Reference No:	<b>2023/62/91025/W</b>
Site Address:	45, Briarfield Gardens, Dalton, Huddersfield, HD5 9JN
Description:	Erection of single storey side extension and conversion of existing garage to games room
Recommending Officer:	Laura Yeadon

**DECISION – CONDITIONAL FULL PERMISSION**

## HOUSEHOLDER DELEGATED REPORT

Drawing
Proposed Floor Plans

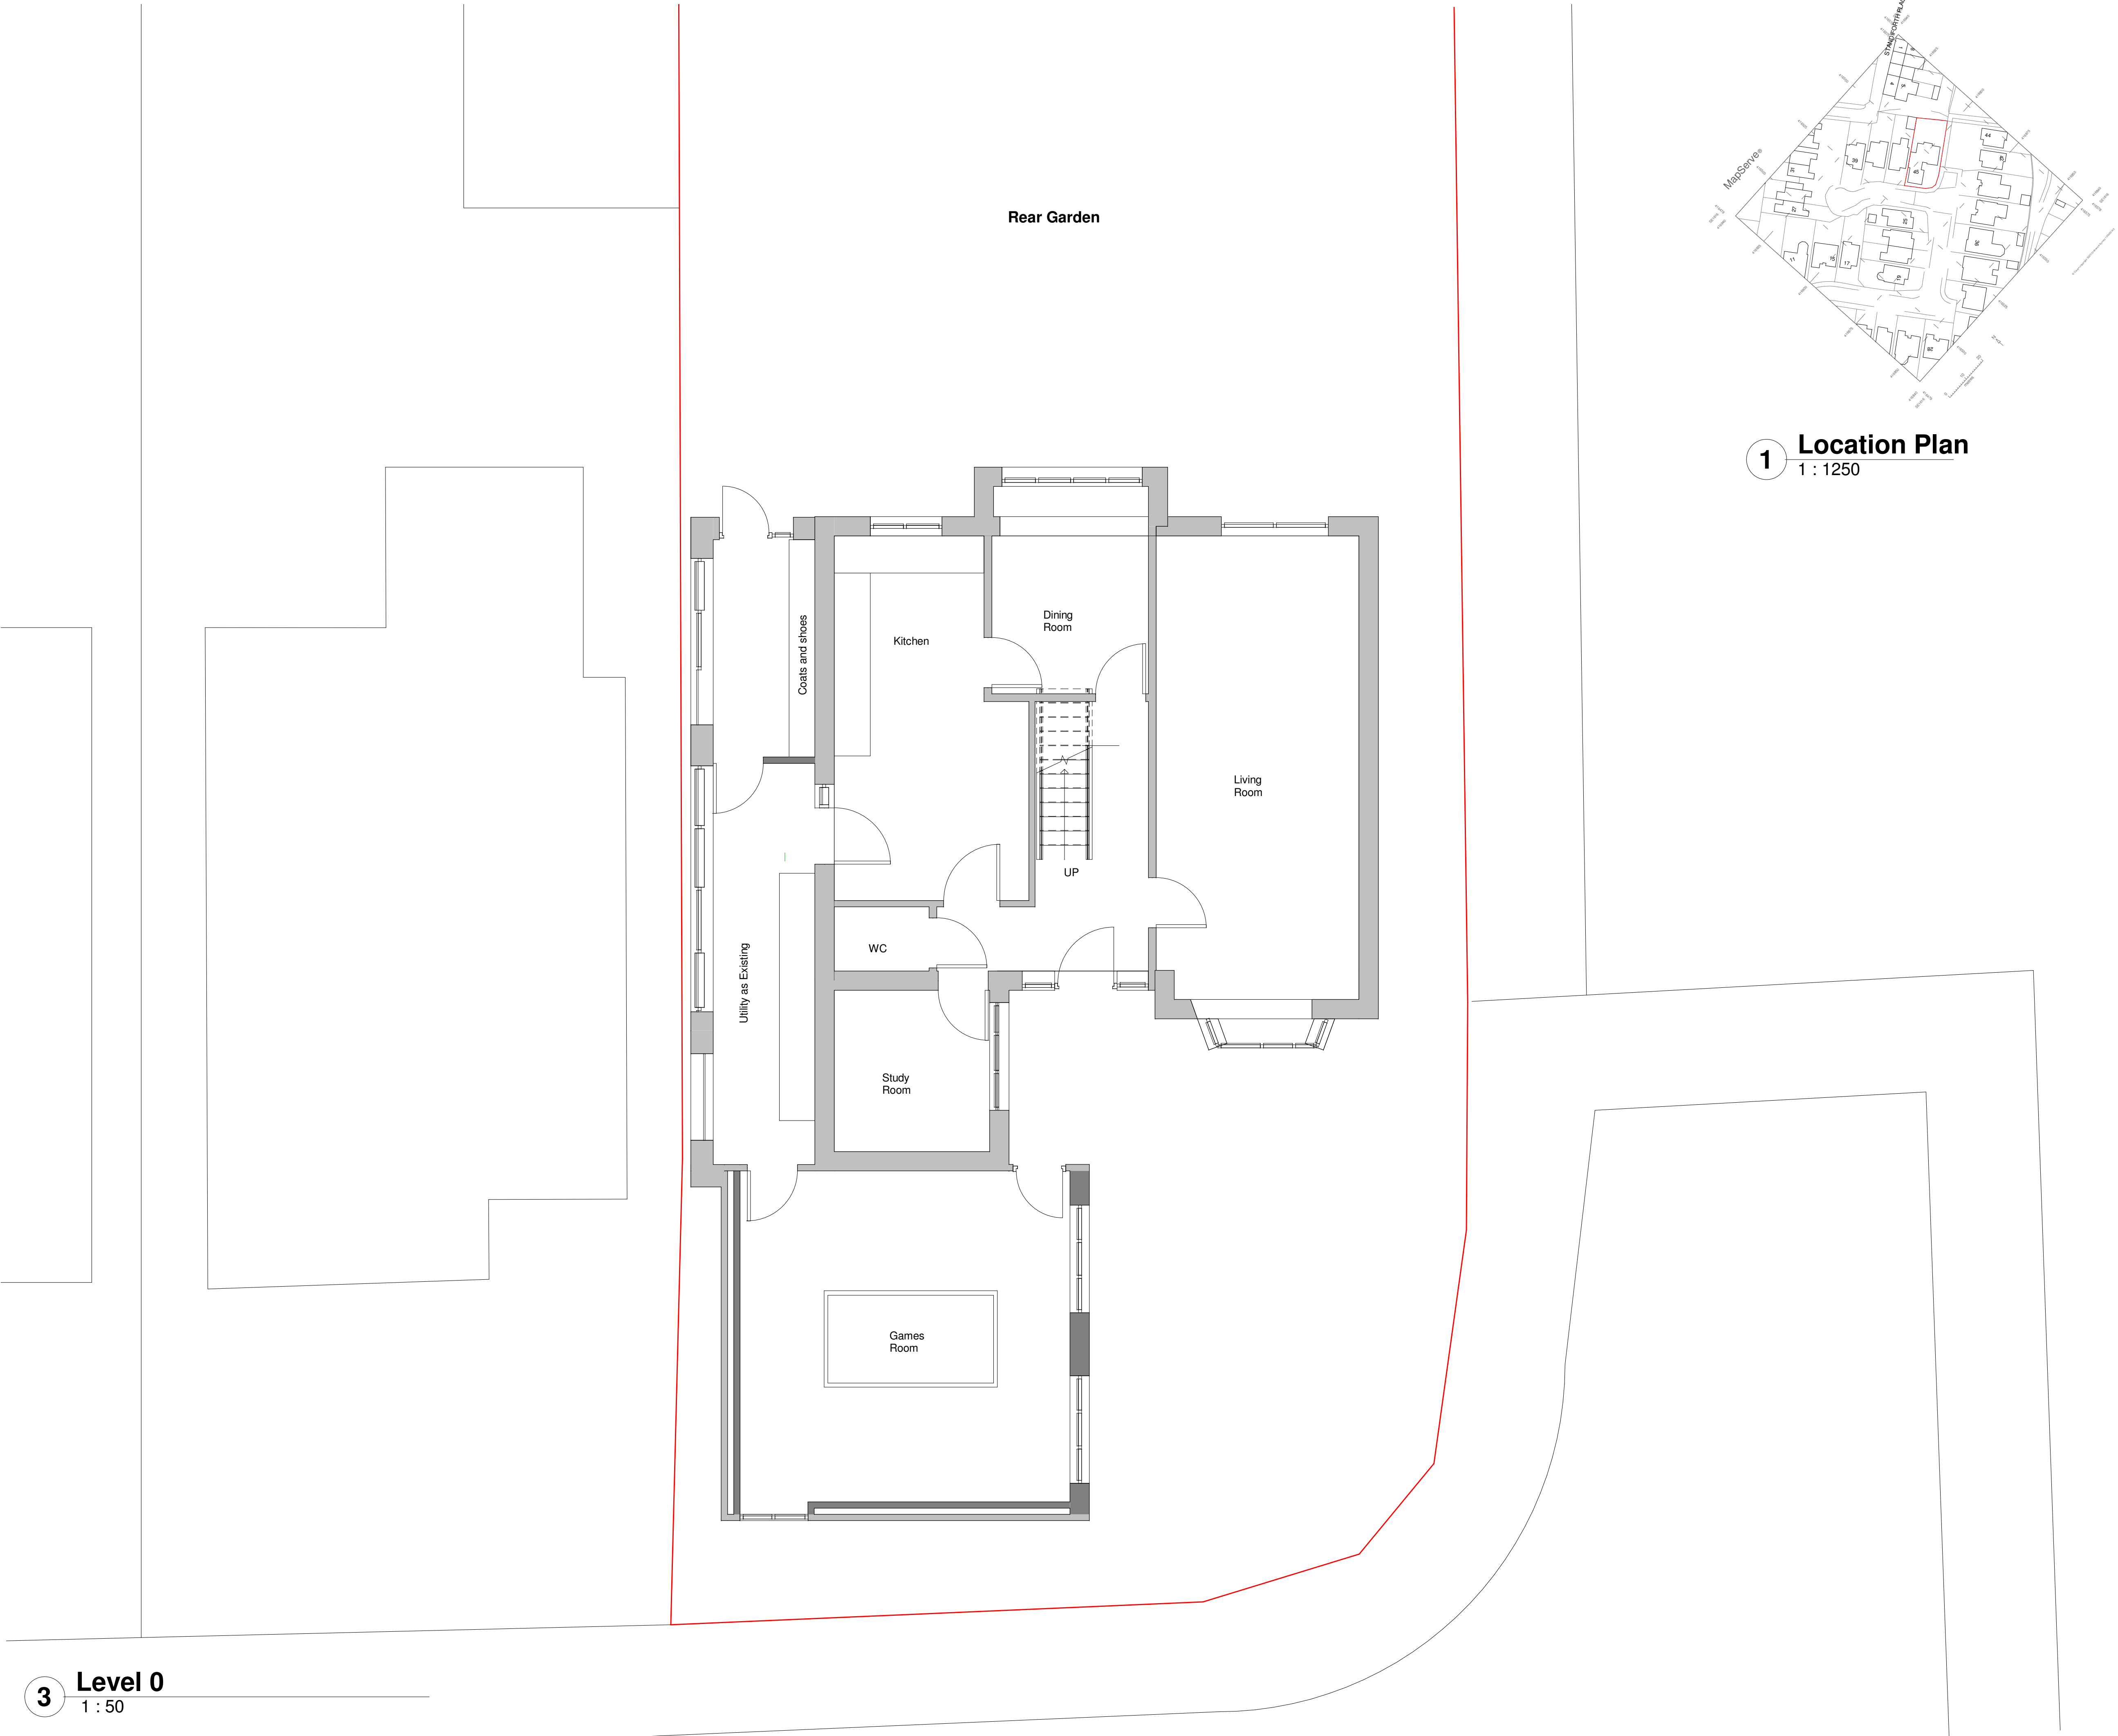
<b>YES / NO</b>	<b>SUMMARY</b>
Negotiations/Amendments during course of application	No	Updated plans were submitted to include additional openings at the request of the applicant – additional high level window in side extension and additional window in east elevation of garage structure
Parish/Town Council comments sought	N/A	
Planning History		<ul style="list-style-type: none"> <li>• 1998/90761 – outline application for residential development – approved</li> <li>• 1999/91899 – demolition of bungalow and erection of 41 dwellings with associated garage and access roads – Section 106 Full Permission</li> </ul>

The proposed extension would attach to the existing side elevation of the attached garage and span the full depth of the property along the boundary line. The extension would be set in slightly from the rear elevation of the property. The eaves height would be 2.6m with an overall height of 3.1m.

To enable the conversion of the garage, the existing openings would be bricked up and 2 no. windows inserted.

Window proportions	<ul style="list-style-type: none"> <li>• KDP 1 and 2 of the SPD</li> <li>• Policy LP24 Design (a), (c) and (d) of the KLP</li> <li>• Chapter 12 of the NPPF</li> </ul>	Windows within side elevation of extension would be large albeit obscurely glazed openings – openings within garage conversion proportionate and in keeping with existing openings	✓
Accessibility for all users	<ul style="list-style-type: none"> <li>• KDP 17 of the SPD</li> <li>• Policy LP24 Design (f)</li> <li>• Chapter 12 of the NPPF</li> </ul>	Private domestic extension and associated works – no alterations to access to property	✓

4. The single storey side extension shall not be occupied until the north facing windows in the side elevation of the extension hereby approved have been obscure glazed to a minimum level of Grade 4. Notwithstanding the provisions of the Town and Country Planning (General Permitted Development) Order 2015 as amended (or any Order revoking or re-enacting that Order) the obscure glazing shall thereafter be retained for the lifetime of the development.
